**Eastern Creek Business Hub Modification (SSD-5175-MOD-5) & Retail Centre Lot 1  
(SSD-8858)**

**Response to Submissions**

I refer to the Response to Submissions (RTS) submitted for the Eastern Creek applications SSD-5175-MOD-5 and SSD-8858. The Department is requesting you provide additional information before accepting the RTS, as follows:

1:200 @ A1 0 1 2 4 6 10m

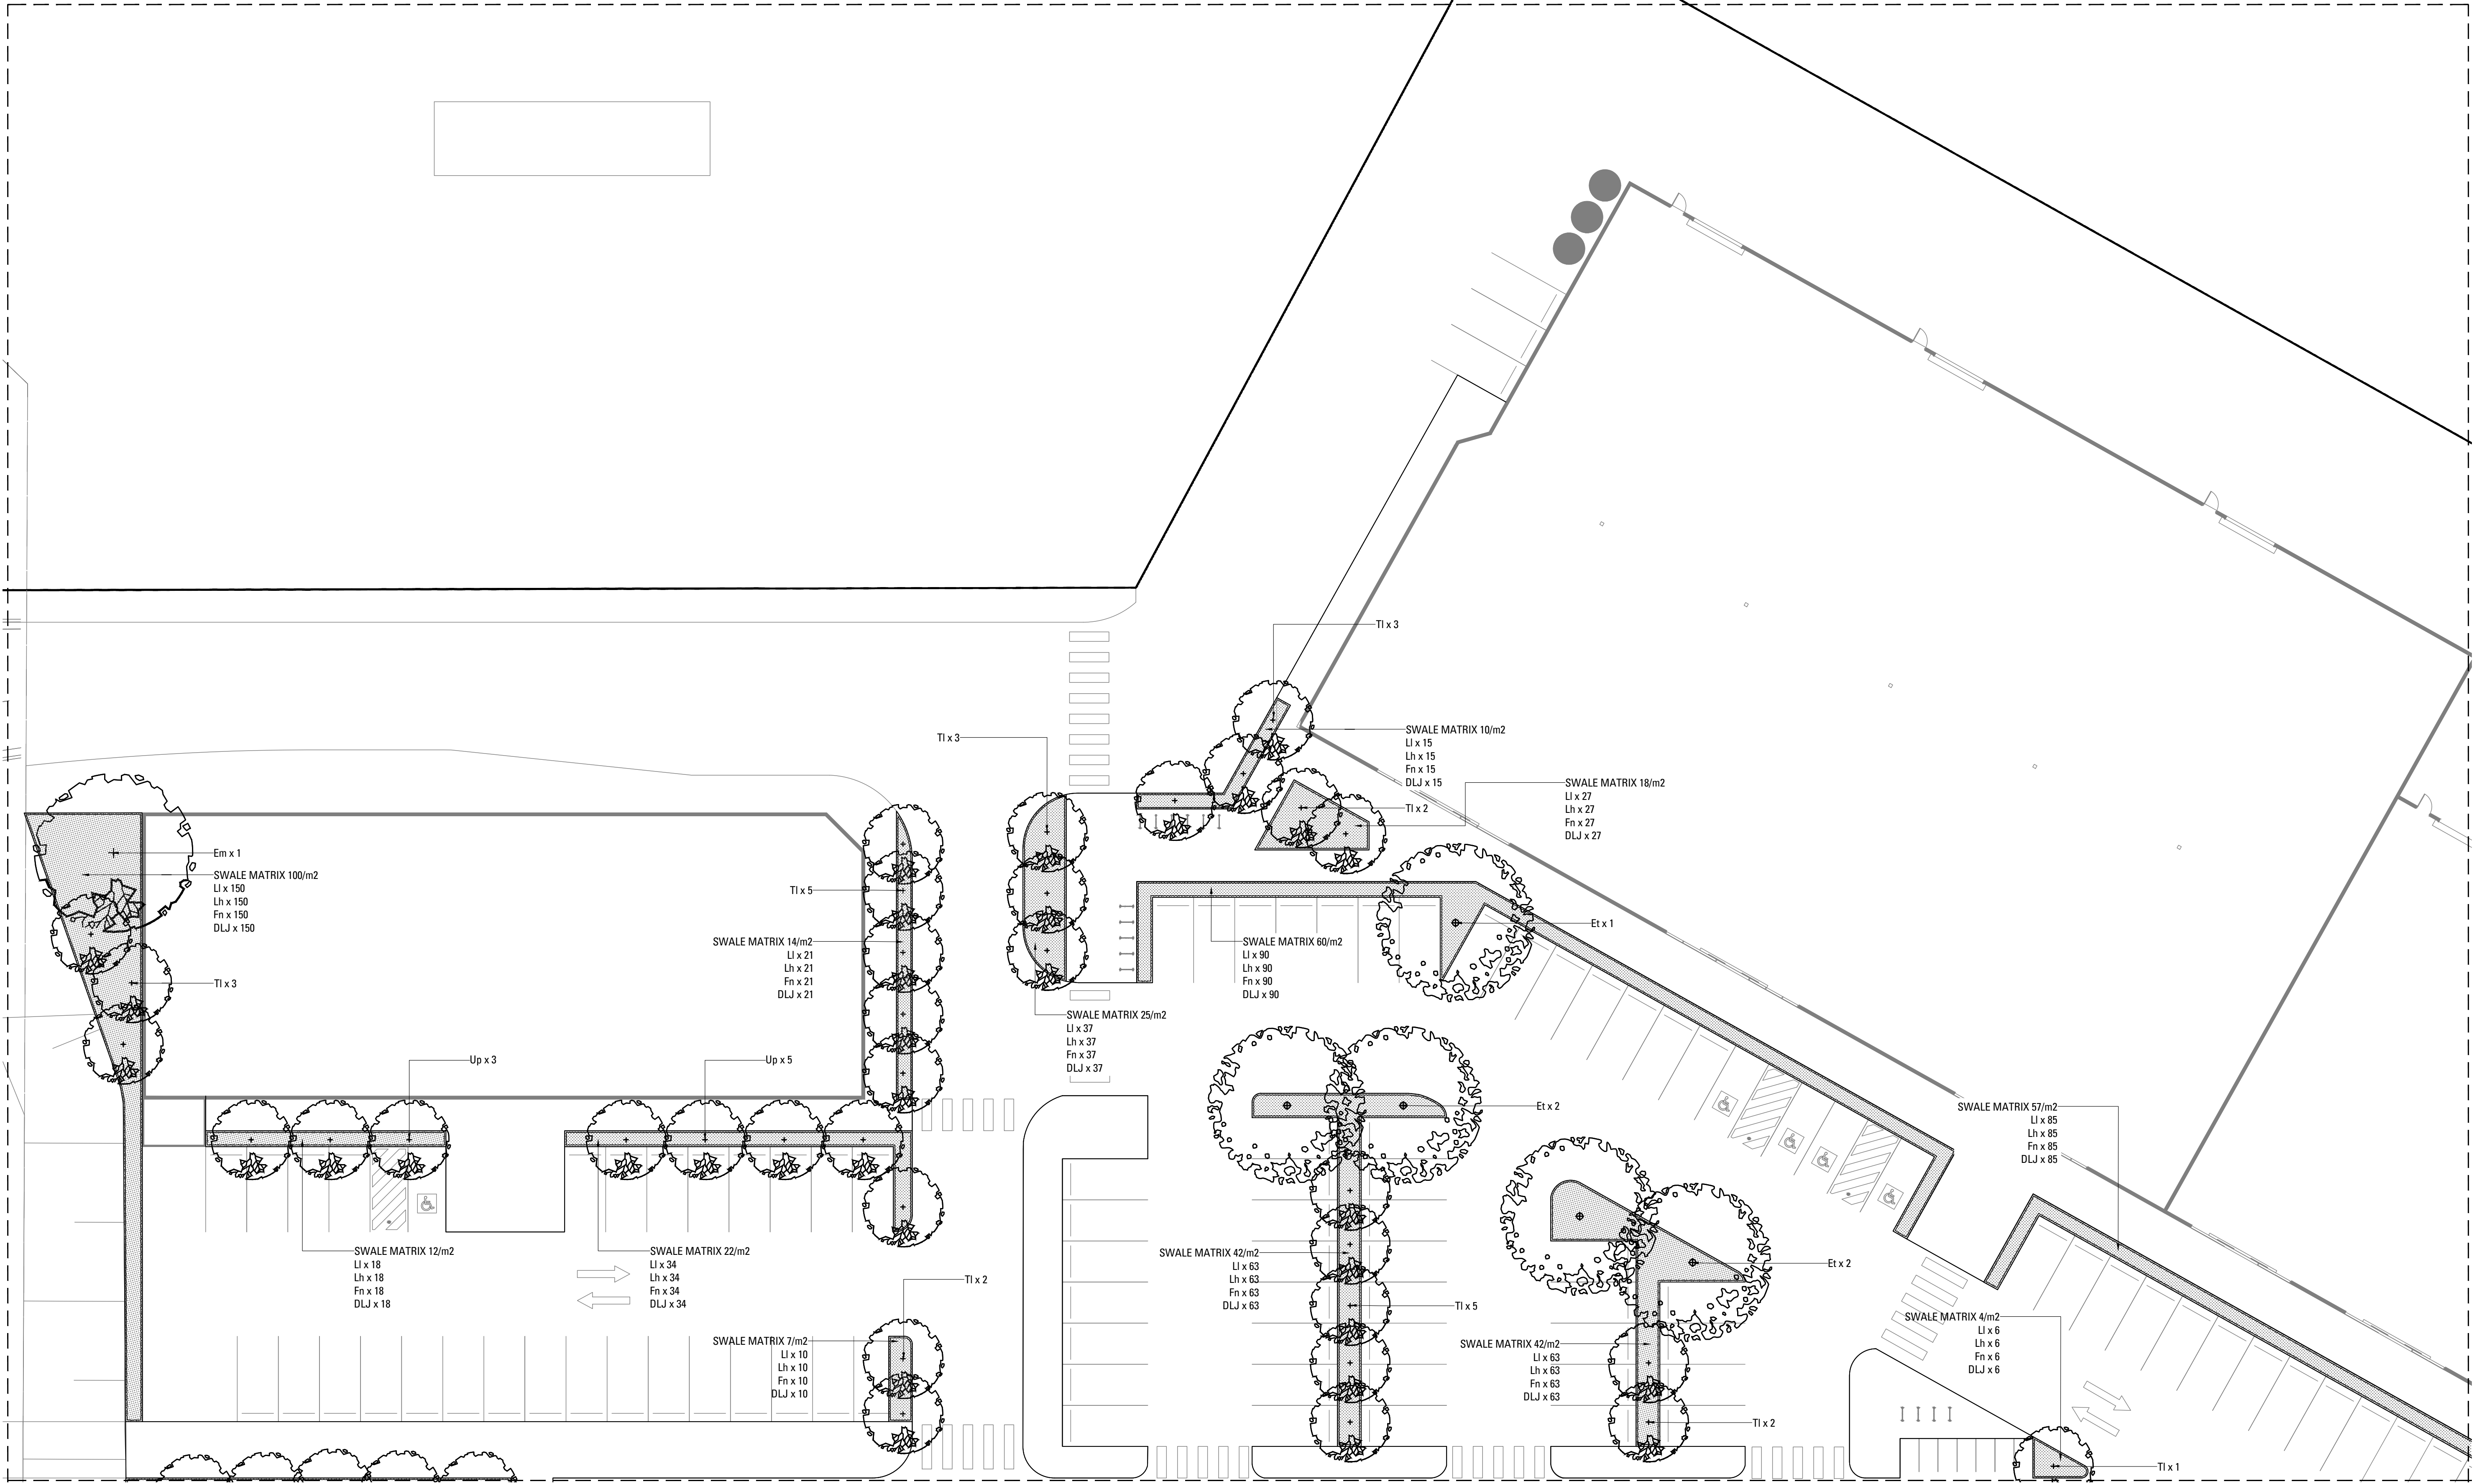
- Identify on the proposed site plan DA04, the three car spaces relocated from the front of Major Tenancy 1
- The amended Landscape Plan has removed the references to the existing trees to be retained on pages 7, 8, 12, 14 and 17 of the document. Re-instate the reference to the retained trees on these pages.
- Provide plan DA06 Elevations Stage 2, as it is missing from the architectural plan set submitted

Figure 2.1: Stage 2 Lot 1 Site Layout

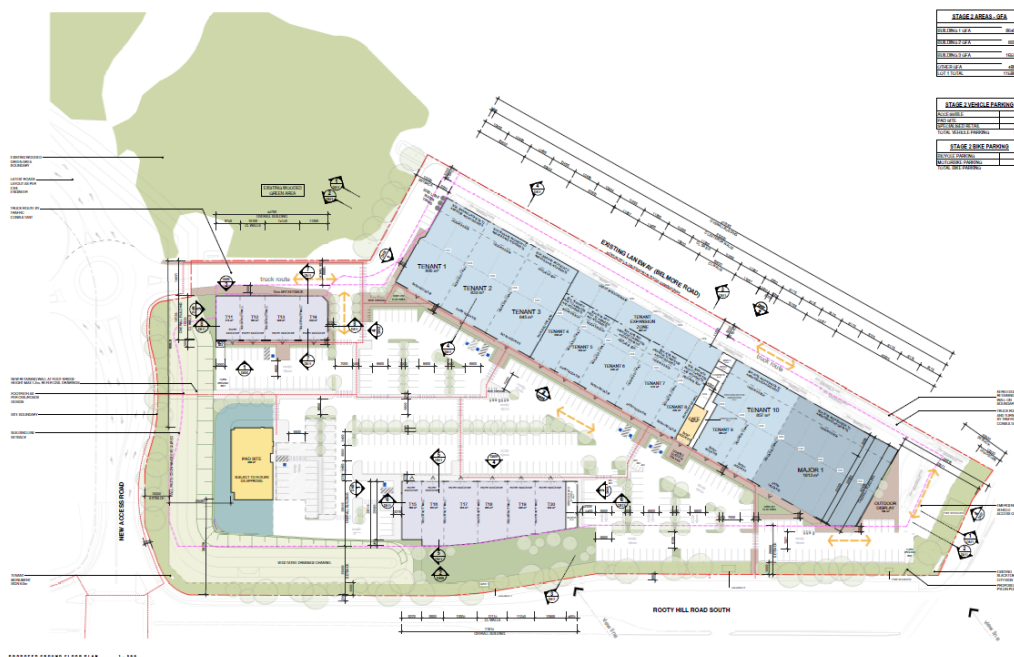
The RTS report advises Major 1 tenancy has been reconfigured which results in an additional 40 m<sup>2</sup> of GFA. However, proposed site plan, DA04, issue G shows the overall GFA of Building 1 as 8450 m<sup>2</sup> (the previous plan shows a GFA of 8400 m<sup>2</sup>).

Provide a GFA breakdown for each building (as was provided on the previous proposed site plan) and confirm the GFA for each building and site overall.
